NSIP Reference Name / Code: A46 Coventry Junctions (Walsgrave) / TR010066

Natural England's response to the submissions at deadline 3

Examining Authority's submission deadline 4 with a date of 22 July 2025

**Noise difference**

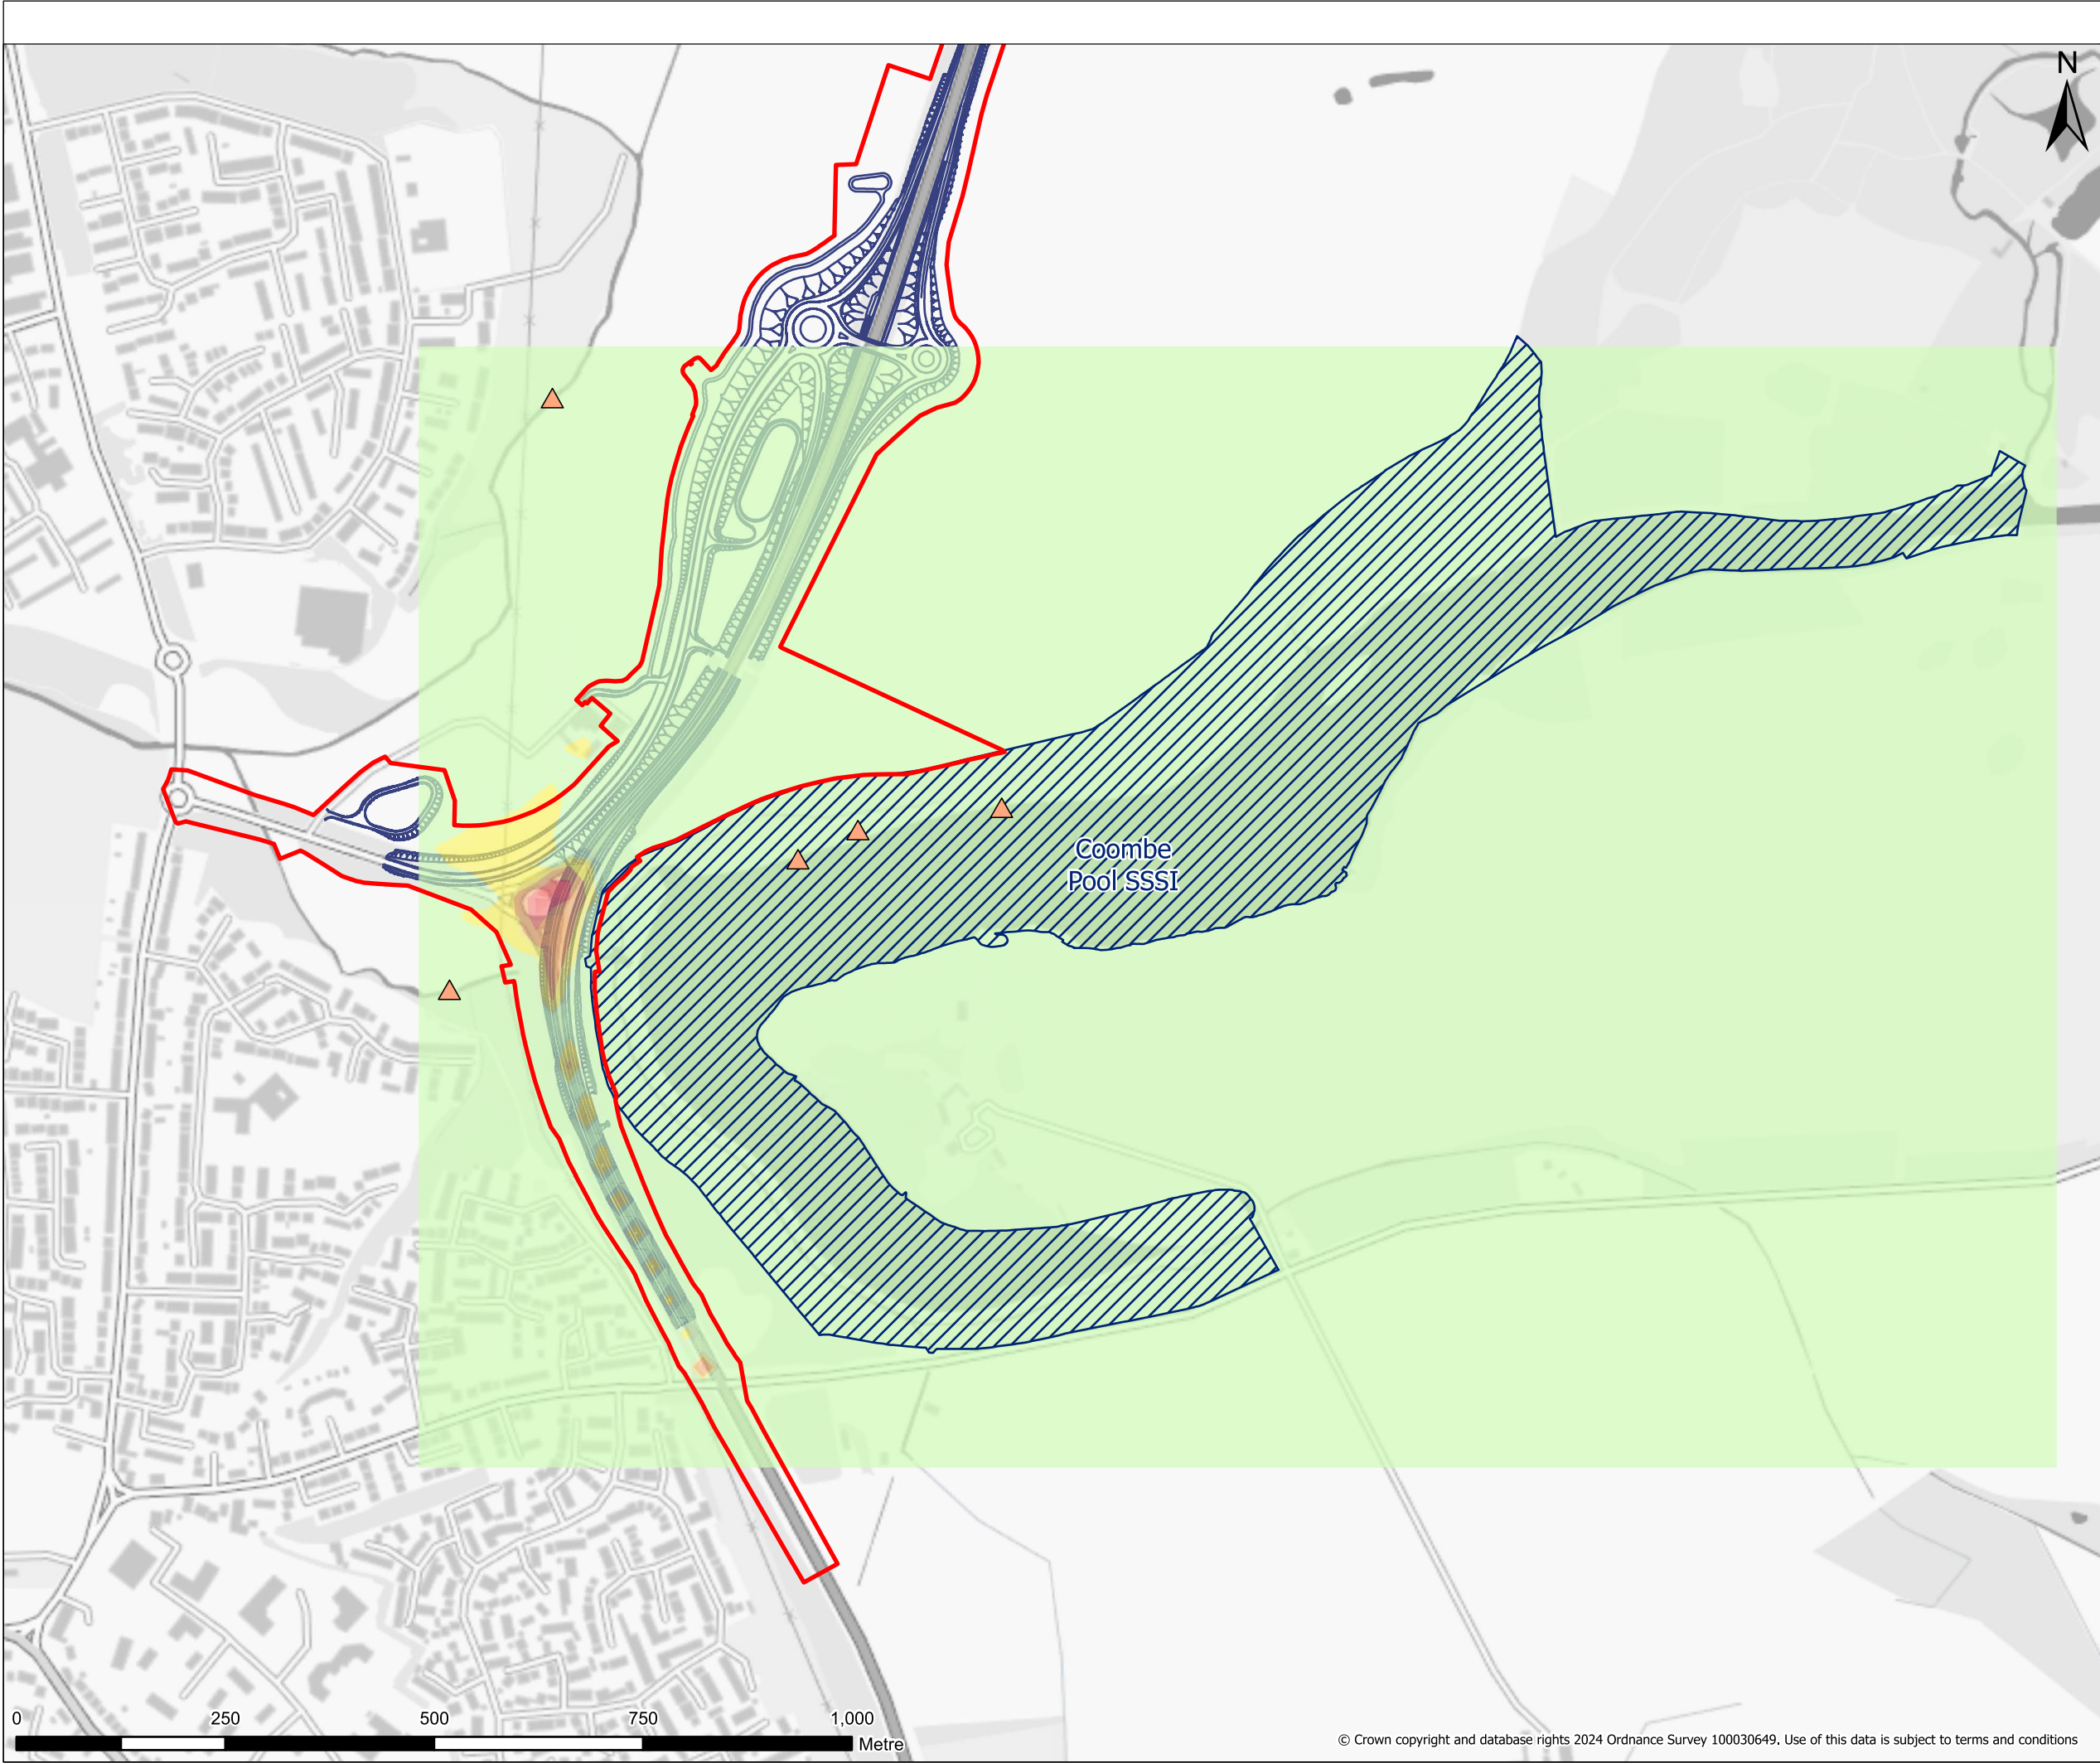
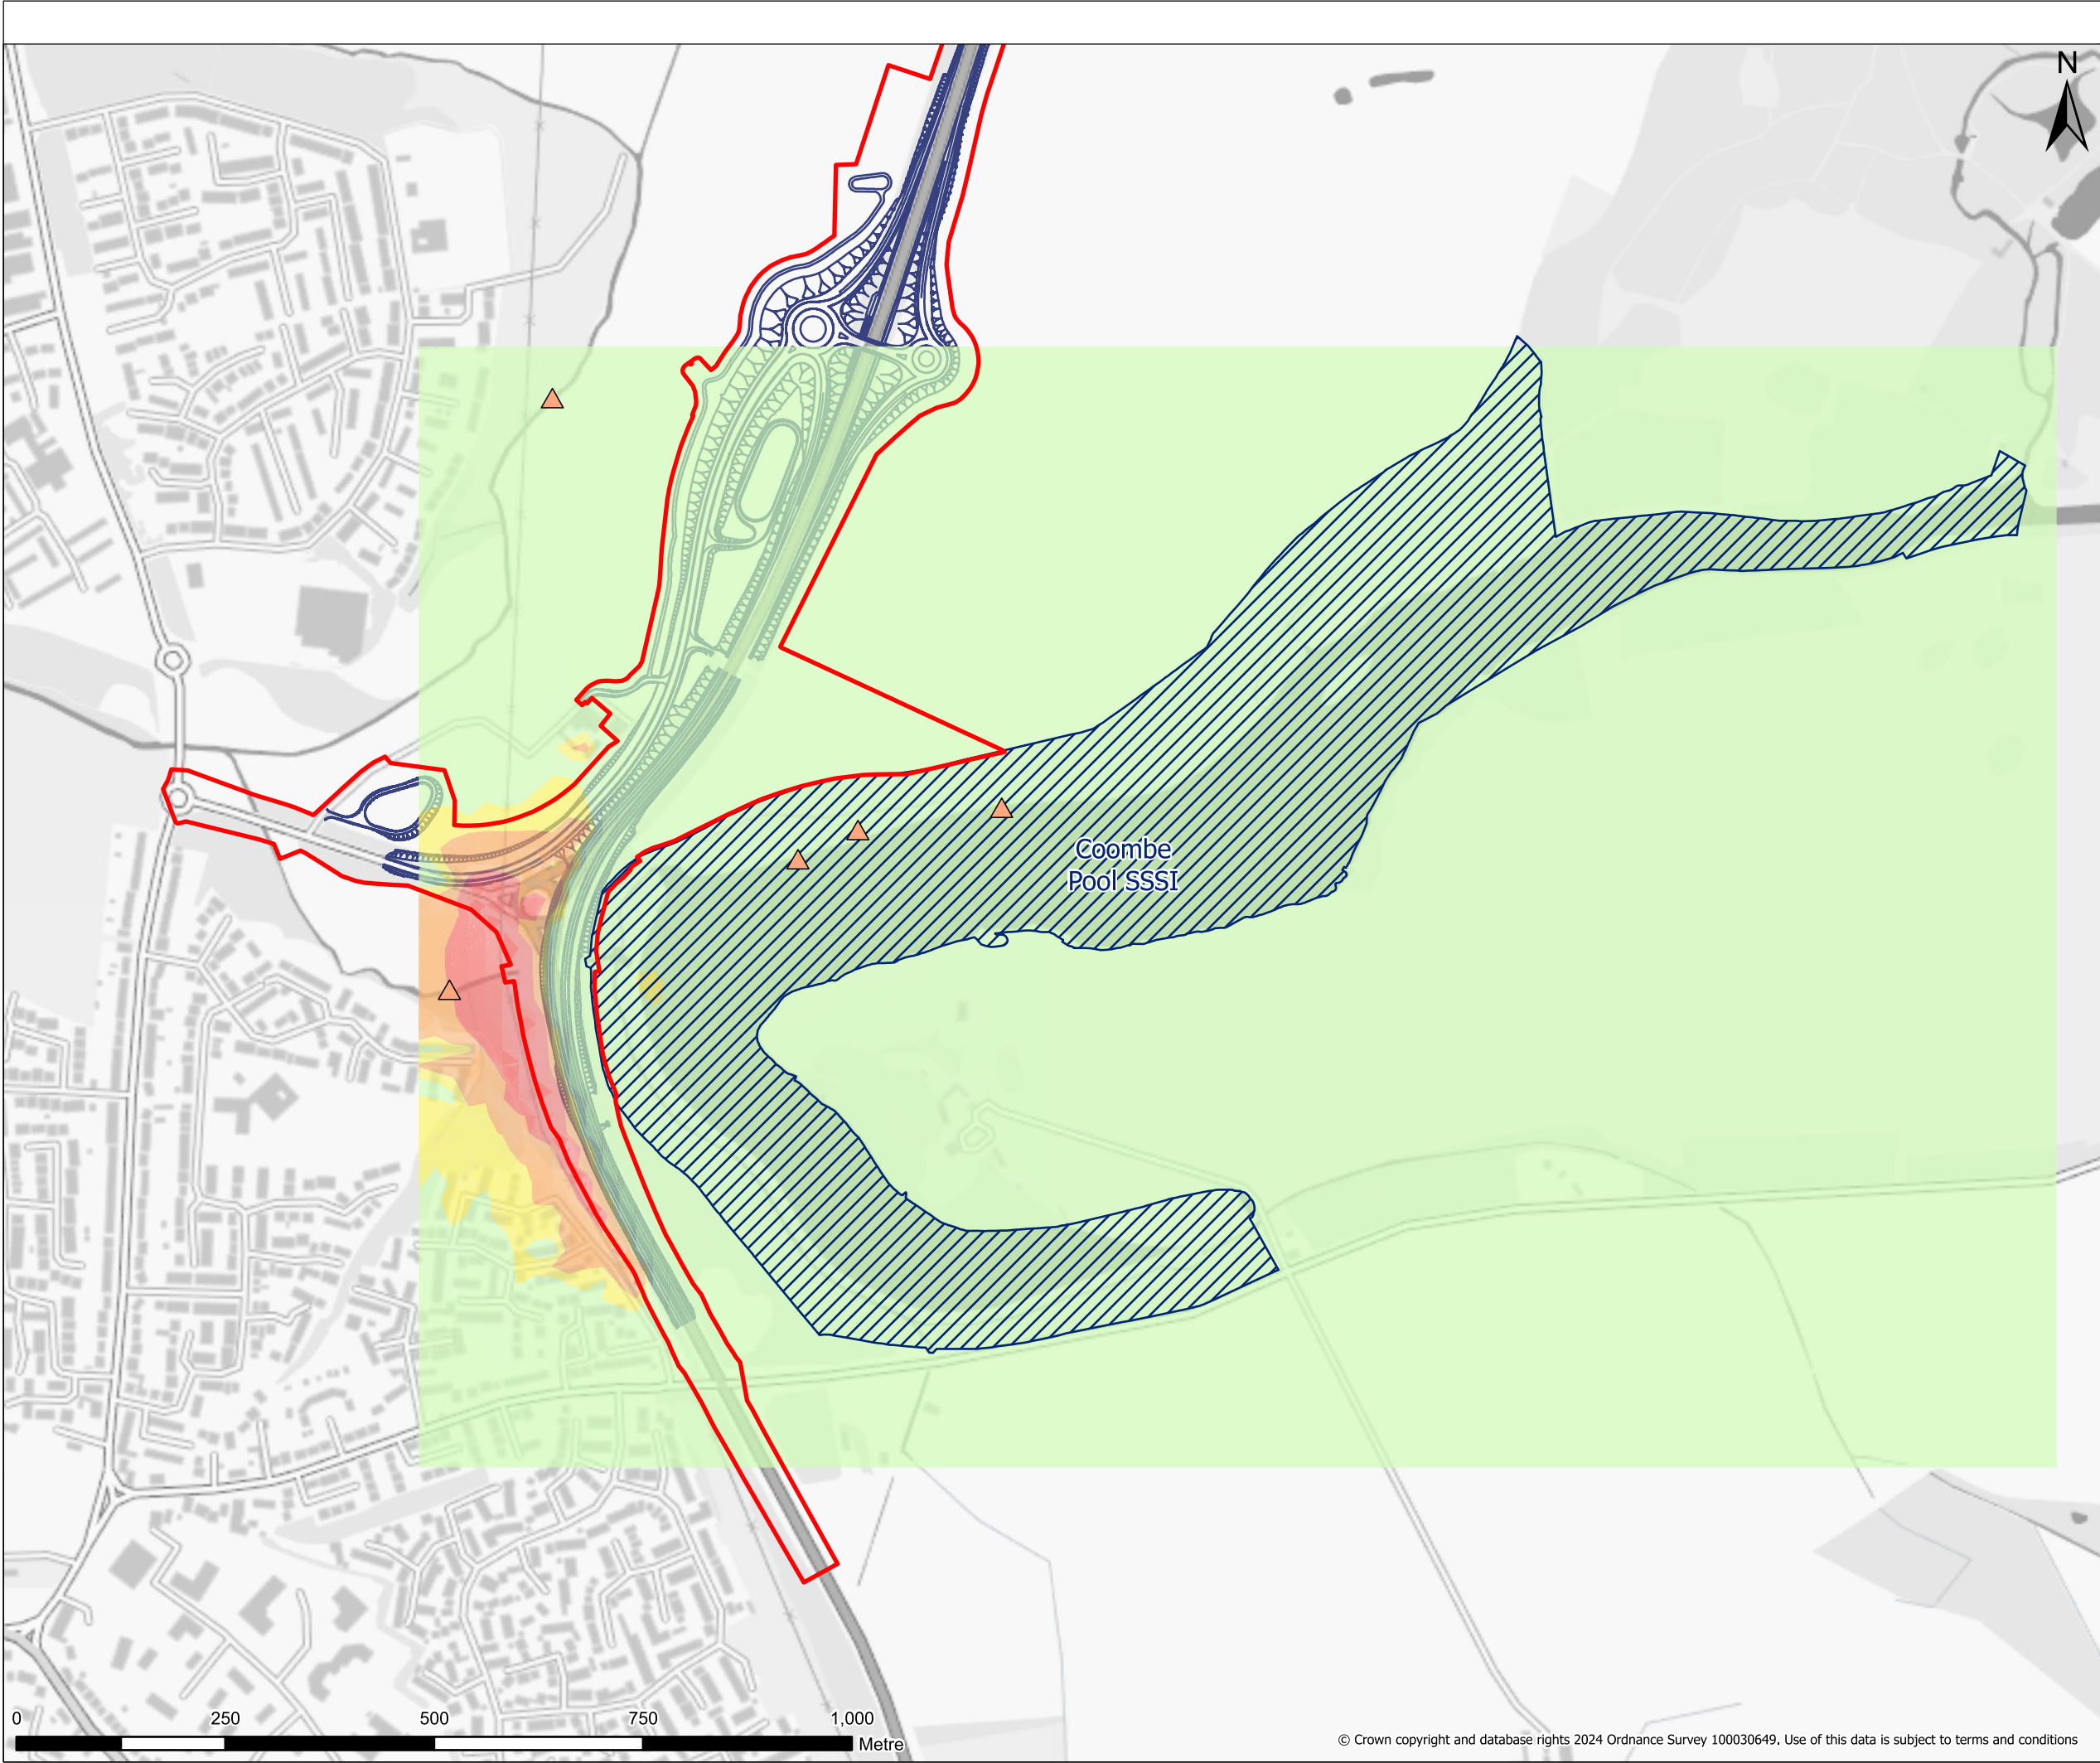
The latest submissions have provided some further information on the noise impacts. Construction noise will result in noise levels above 3dB even with a 2m noise barrier (see Table 1 below) which will impact on breeding waterbirds, wintering waterbirds (including Shoveler) and woodland breeding and wintering within Combe Pool SSSI. There will be an increase in noise levels above 3dB for a portion of the SSSI and a decrease of -1.0dB or less during operation. The modelled background noise levels at the closest edge of the lake to the Order boundary in the do minimum scenario for 2028 will be 61.5dB and 64dB for 2028 if the scheme goes ahead.

From the information provided it appears that the construction noise impacts will not be fully mitigated, and a residual impact remains. We therefore advise that the proposal should include the provision of a permanent noise barrier to mitigate for residual operational noise impacts on breeding and wintering birds.

Traffic is predicted to continue to increase over time (Source: [National road traffic projections 2022](#)) and it is likely that noise levels within the SSSI will also continue to increase for the operational stage of this road scheme. Low woodland breeding and wintering bird numbers have already been identified, which the Applicant partly attributes to the proximity of the existing road (2.1.24 REP3-028).
